# Rezoning Transportation Analysis

Petition Number: 2020-165

General Location Identifier: Tax ID 02516105.

Date	Description
12-28-20	First Review (EL)

SCHEMATIC  
 SITE PLAN

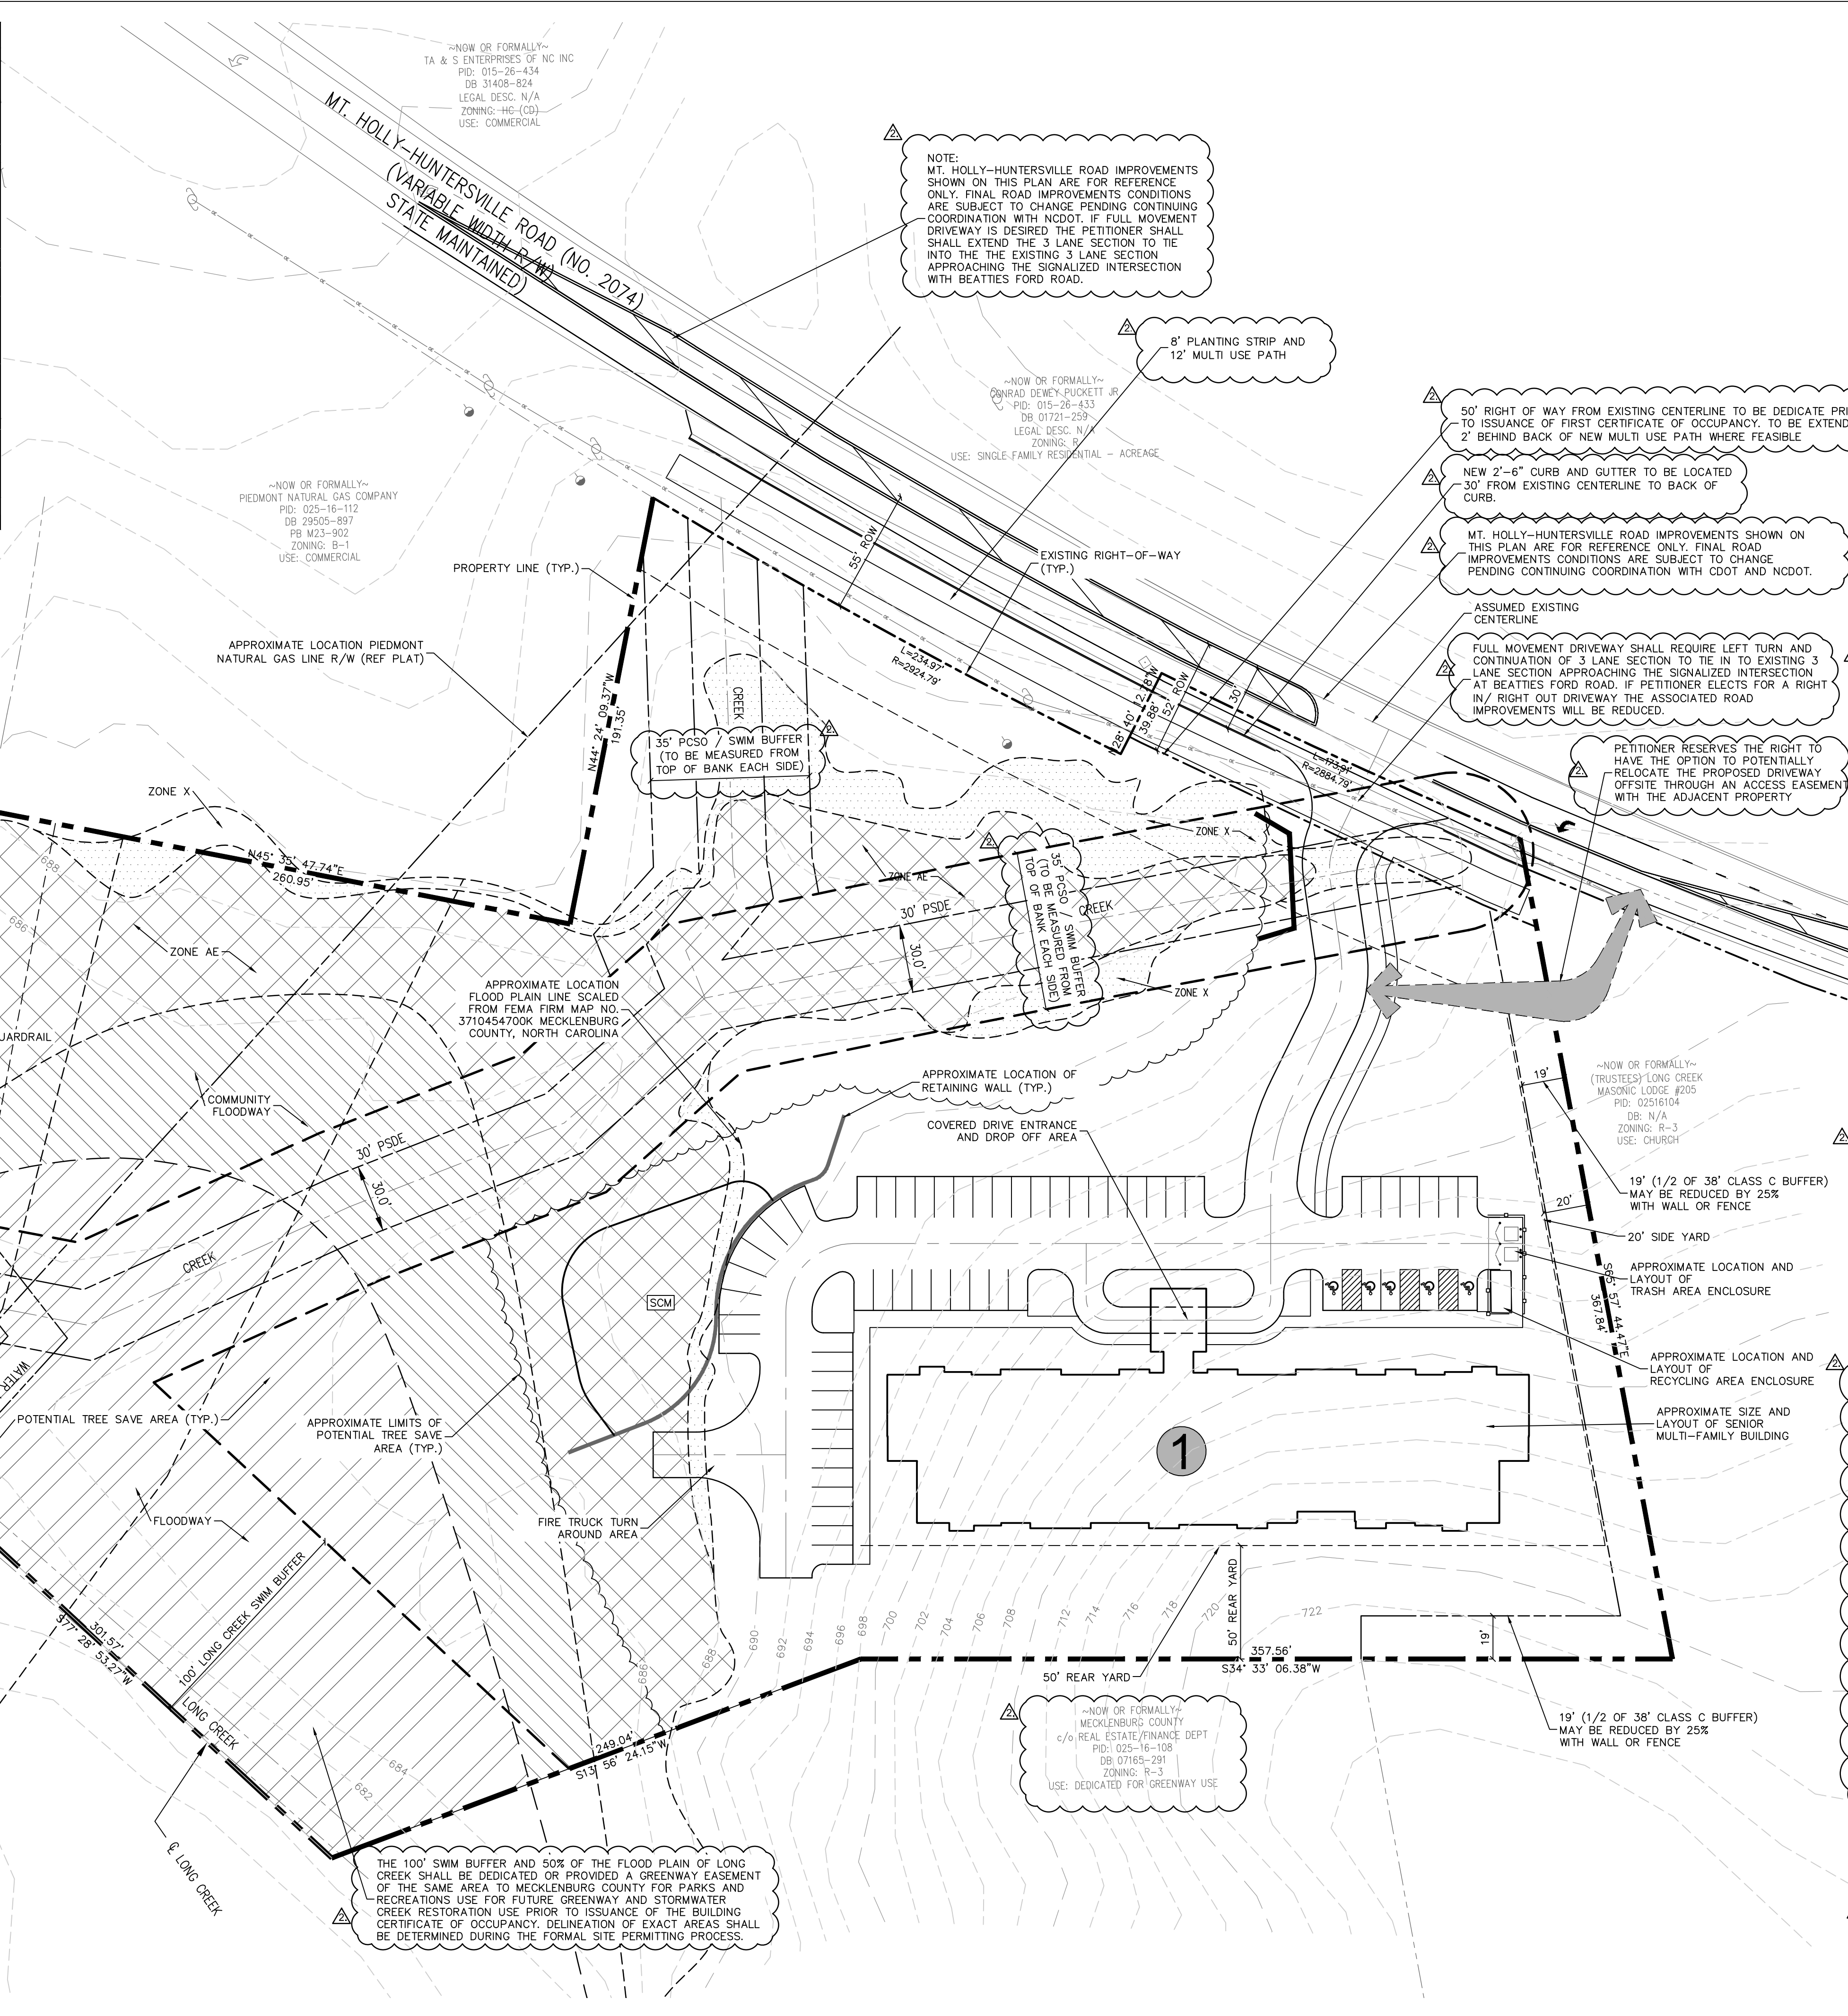
- a. **Mount Holly-Huntersville Road:** The future location of curb and gutter is 30-feet from centerline to the proposed back-of-curb, to accommodate a future 4+ Avenue road cross section.
- b. **Beatties Ford Road:** The future location of curb and gutter is 19-feet from centerline to proposed back-of-curb, to accommodate a future 2+ Avenue road cross section.

Label and dimension the curb and gutter from the centerline for each road on the site plan.

3. Revise site plan and conditional note(s) to commit to dedicate a minimum of 50-feet of public right-of-way from the Mount Holly-Huntersville Road centerline. Label and dimension the right-of-way from the road centerline.

4. Revise site plan and conditional note(s) to commit to dedicate a minimum of 38-feet of public right-of-way from the Beatties Ford Road centerline. This request is greater than the required 35-feet of right-of-way to be reserved for a minor thoroughfare, in order to accommodate the future 2+ Avenue cross section. Label and dimension the right-of-way from the road centerline.

5. Revise site plan and conditional note(s) to commit to construct a required minimum 8-foot planting strip and a requested 12-foot shared-use path in lieu of the required 6-foot sidewalk on Mount Holly-Huntersville Road, as required per Chapter 19 of the City Code. The requested 12-foot shared-use path meets the City Charlotte BIKES Plan and the goal to improve pedestrian and bicycle connectivity throughout the City. Label and dimension both items from the back of curb and gutter and road centerline.

6. Revise site plan and conditional note(s) to commit to comply with the requirements of Chapter 19 of the City Code, to address the road improvements required along Beatties Ford Road.

7. In coordination with NCDOT, revise the site plan and conditional note(s) to construct a left-turn lane on Mt. Holly-Huntersville Rd, with a three-lane section extending to the signalized intersection with Beatties Ford, if a full movement access on Mount Holly-Huntersville Road is desired. To limit pavement widening, a right-in/right-out access may be proposed on Mount Holly-Huntersville Road, if constructed per NCDOT standards.

8. CDOT recommends revising the site plan and conditional note(s) to acquire an access easement from PID 02516104, to avoid impacting the stream and constructing the proposed culvert crossing.
